DECISION DELEGATED TO DEVELOPMENT MANAGER
--

Application No:	H11-1034-19	Applicant:	Mr & Mrs Brown
Proposal:	Storage outbuilding		
Location:	Tenmay 172 Seagate Road Long Sutton		
Terminal Date:	19th January 2020

BLOCK PLAN
1:500

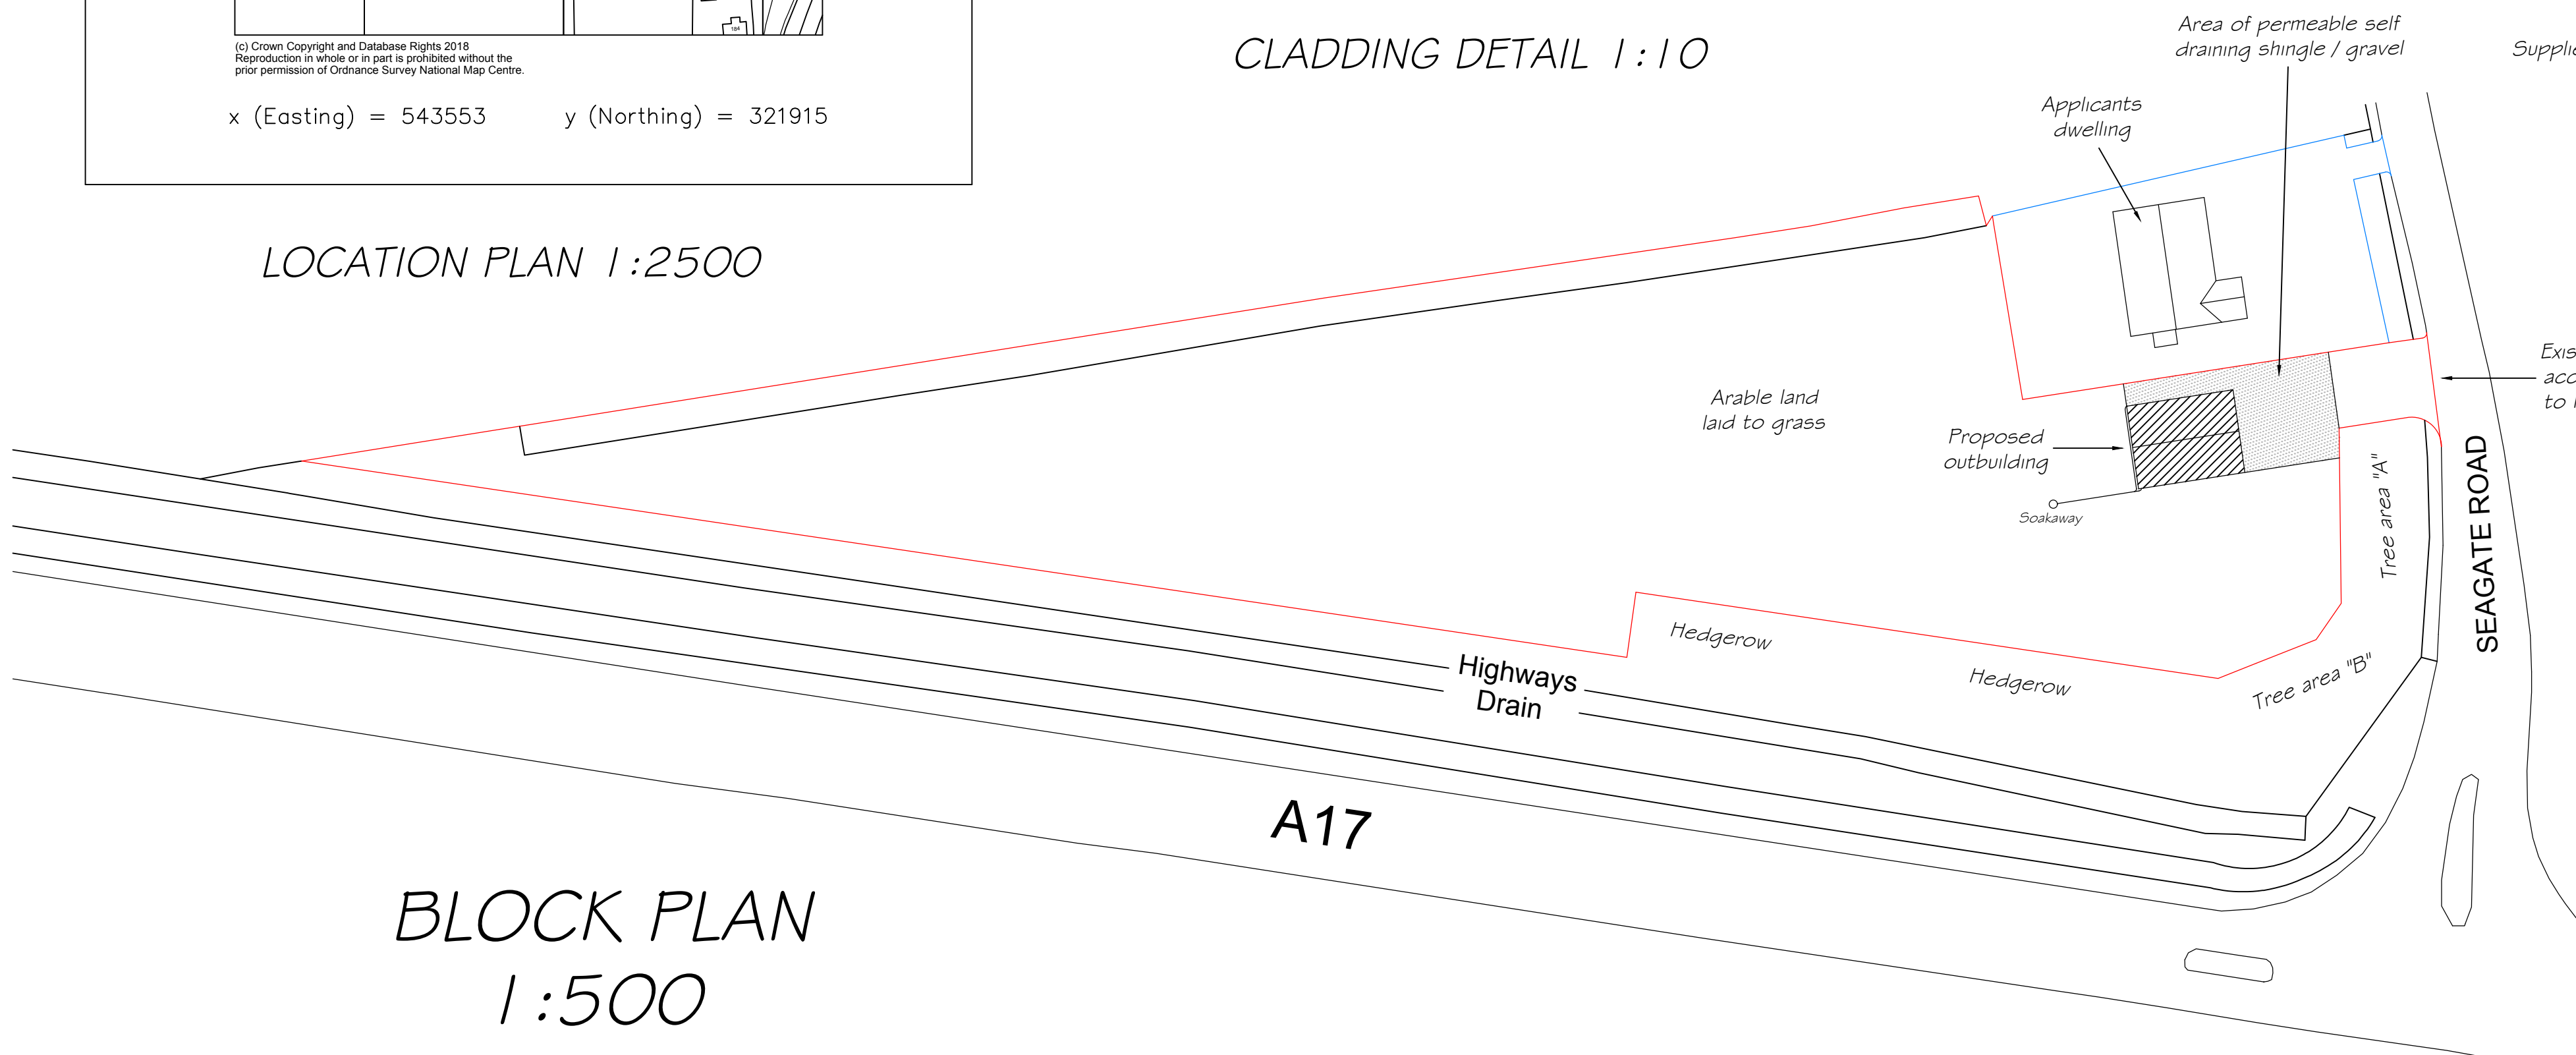
The outbuilding is proposed to be positioned on the other side of the brick wall to the south of the dwelling's curtilage.

- Siting of proposals is ill-considered as it will impact on views of the countryside and should be

moved to the rear of number 172 in order to be considered.

The Local Planning Authority does not consider there to be a risk to residential amenity of any nearby residential properties. This is because the proposed building is single storey and non-residential and so cannot be considered to present a risk of overlooking to any nearby properties. Additionally, due to the single-storey nature of the proposal coupled with its distance from any of the surrounding residences, it is not considered that the proposal will present any risk of overshadowing any residences.

PROPOSED SIDE ELEVATION (SOUTH)
1:50

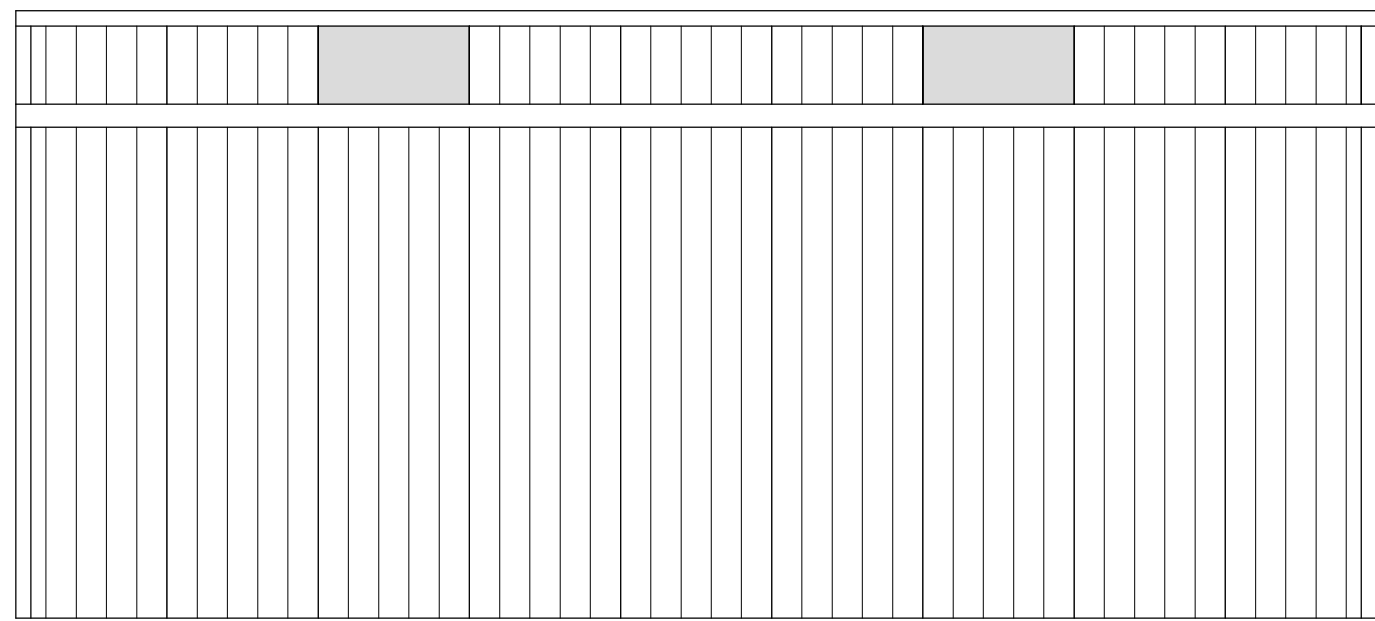
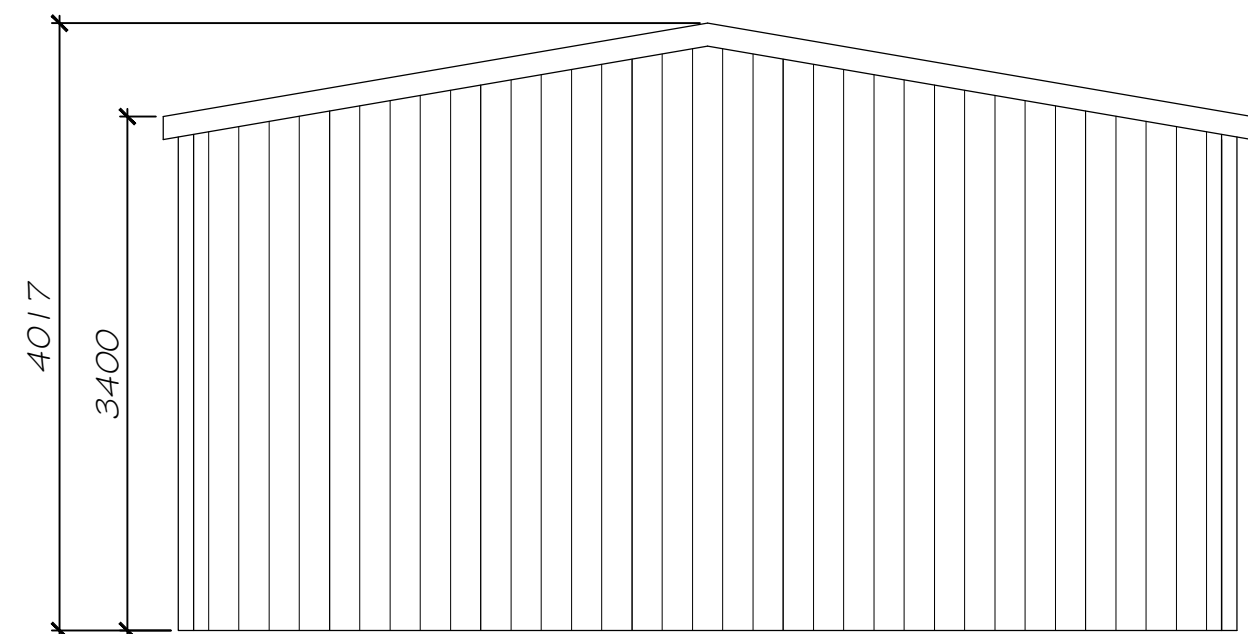
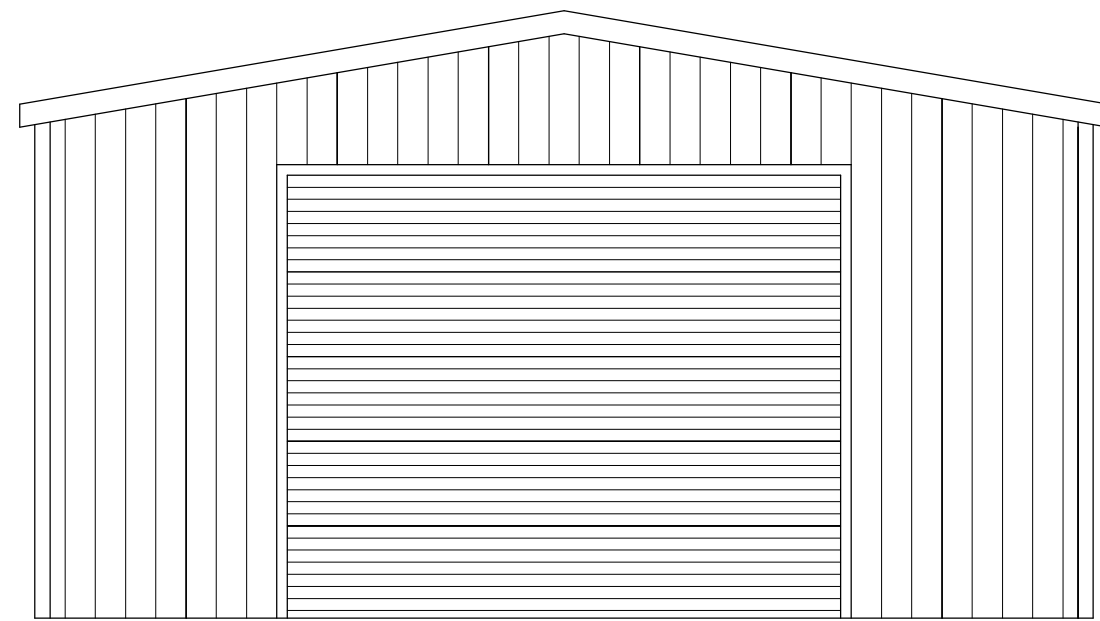
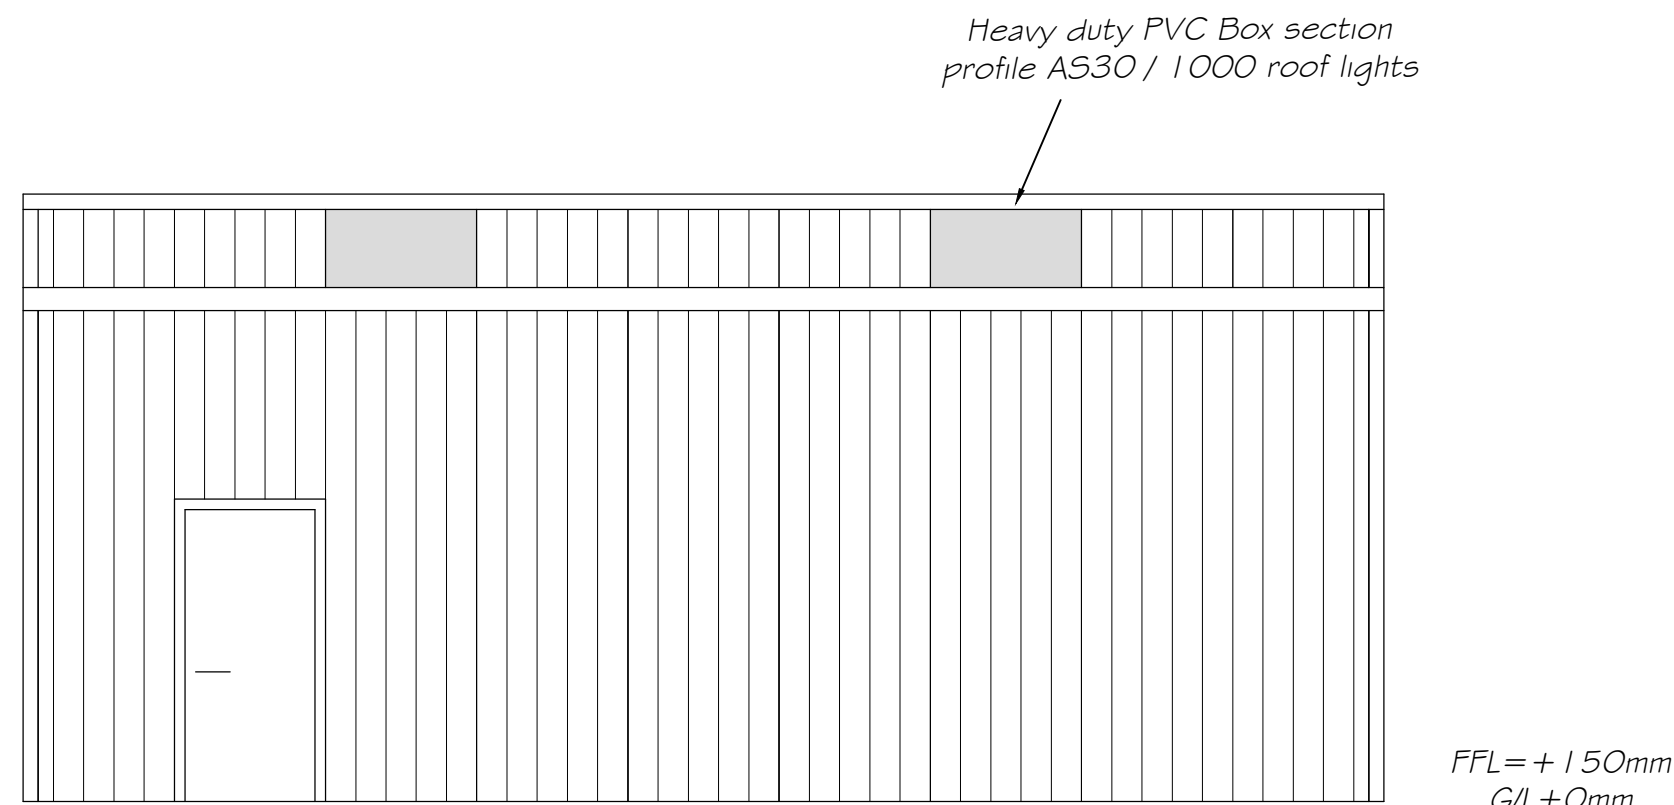
- Proposal is too large and would be very similar in size to the host property itself and many other nearby properties. As such it is out of character in the area and is thusly in contravention to paragraph 127(c) of the NPPF which states that proposals should be sympathetic to local character, history, surrounding built environment and landscape setting.

- No other similar buildings along Seagate Road and the colour, scale and materials are alien to the area as such is out of keeping with its surroundings.

Objectors also raised concerns over the colour and materials proposed, suggesting that they would be out of keeping for the area. However, the site is not within a conservation area that requires limitations on material types beyond what is appropriate and reasonable and the box section steel is a commonly used material for such structures that is present on several such buildings in the area. The olive green can be considered to be highly suitable for the proposed structure as it is a muted tone that should help to blend the structure to the surroundings and will not be a distracting or offensive tone.

The Local Planning Authority does not seek any amendment to the design or layout of the proposal. This is because the design of the proposal is deemed to be appropriate to the area and 172 Seagate Road. The structure is proposed as an agricultural style structure for the storage of agricultural equipment (amongst other things) in an agricultural/open countryside area. The materials are appropriate to the structure and area - box section steel cladding is a common material for such structures and the proposed uPVC fittings would not be alien to the area.
